Recommendation Report for Planning Permission for Works or Extension to a Dwelling

REF NO: FG/2/21/HH

LOCATION: 3 Sea Drive
Ferring
BN12 5HD

PROPOSAL: Erection of a detached garage.

SITE PLAN 1:500 @ A4

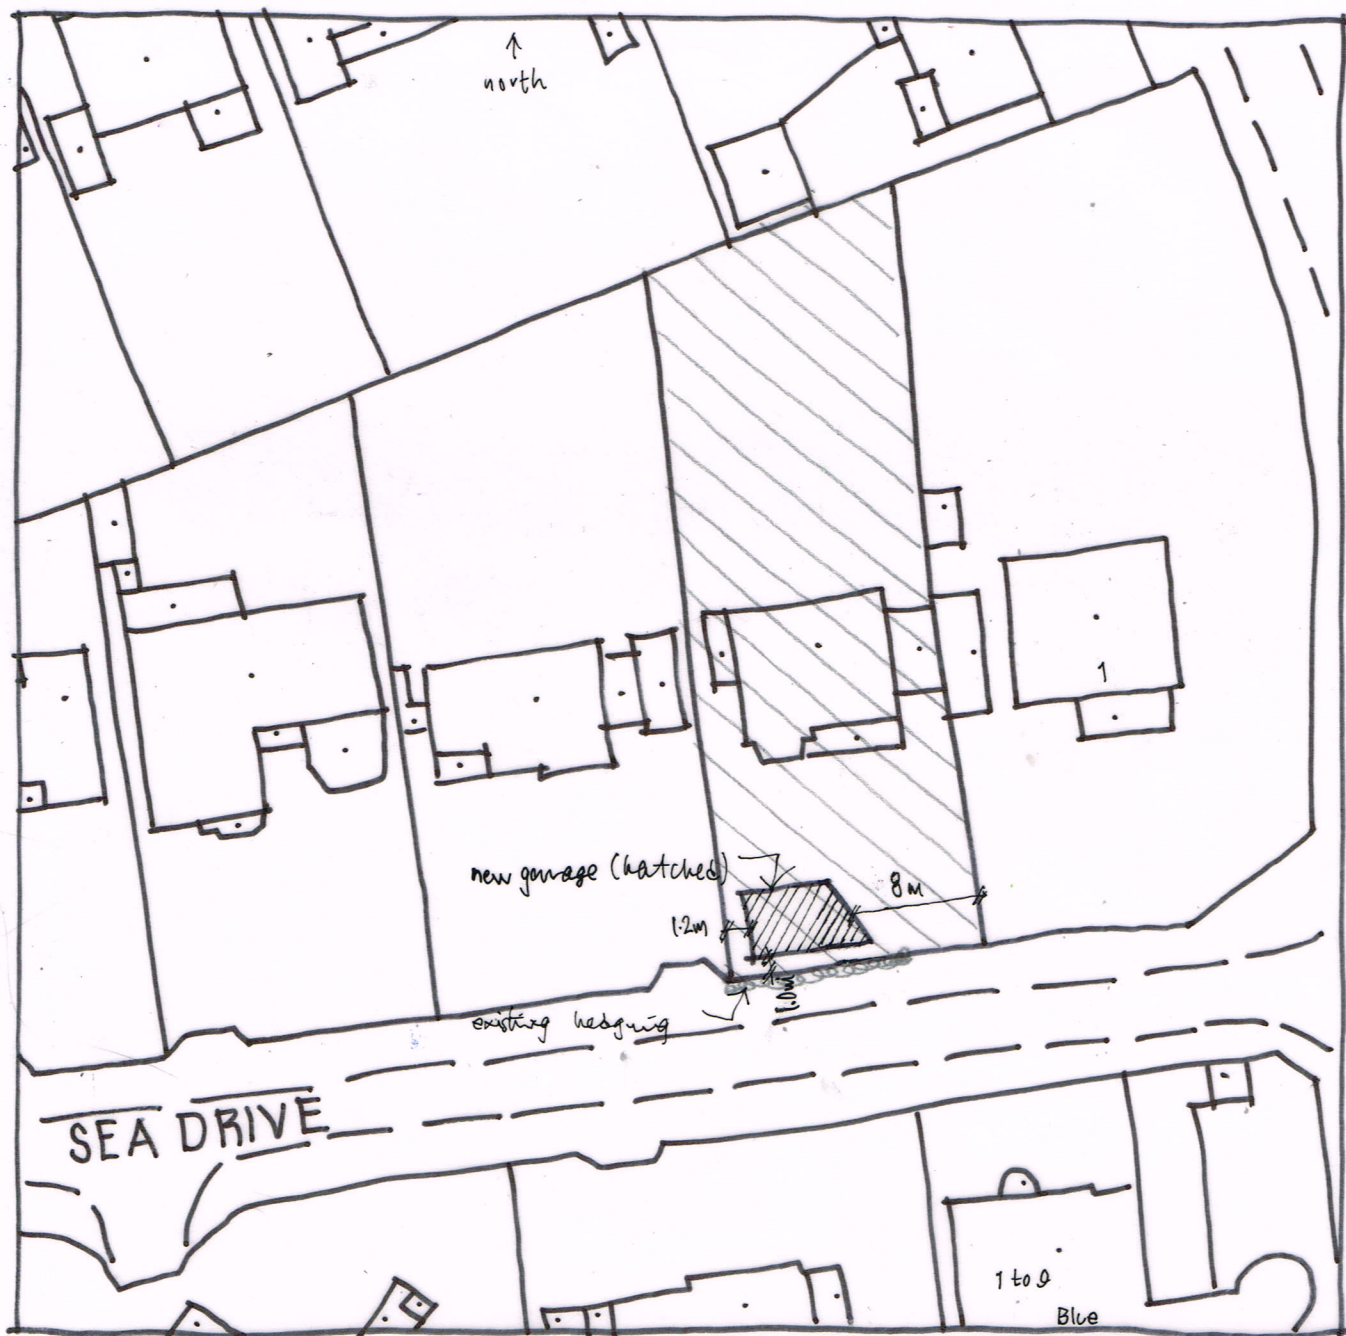
The character of the locality is considered to a mixed, as a result of the variety of dwelling styles, siting and scales along Sea Drive. The proposed garage is sited within the front garden of the host dwelling and will be the first of its kind along the Northern side of Sea Drive. To the Southern side of the road, there is one example of visible built form, which is a small bin store. The road can be considered to be characterised by high hedges adjacent to the roadside, as there are many examples of this along Sea Drive.

The proposed garage measures 8.1m wide, 4.5m deep and 2.6m high, sited in the South Western corner of the application site. The boundary treatment to the front boundary of the property is host to hedging of approximately 3.1m in height, with the side boundaries bordered by 2m high walling. As such, it is considered that there will be limited views of the proposed garage (including its roof) from within the street scene and therefore not significantly and harmfully impact upon the character of the locality.

SIDE (S) ELEVATION 1:100 @ A3

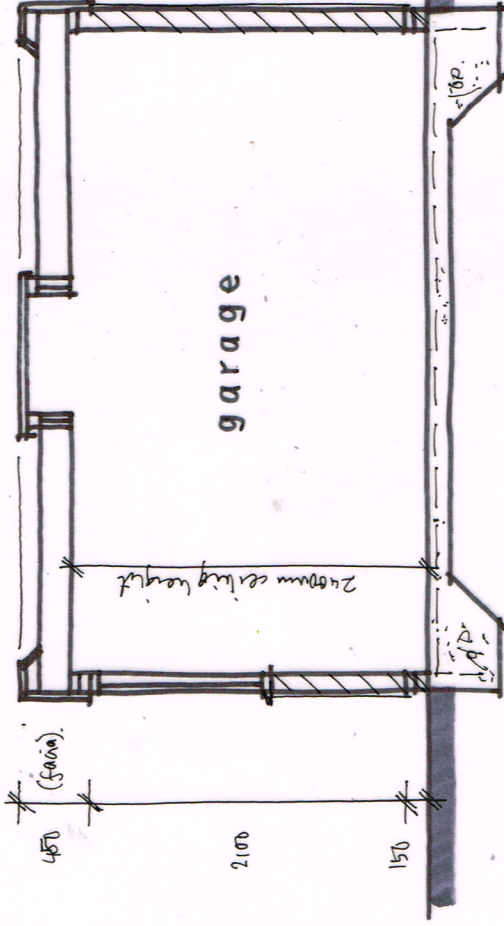
- The garage is forward of the building line.
- The hedge could be removed.
- The area predominantly has low hedges and fences to the front boundaries of the dwellings.
- The proposal would set an unacceptable precedent.
- The proposal may lead to light pollution.
- The roof is an odd shape.
- The proposal infills the garden area.
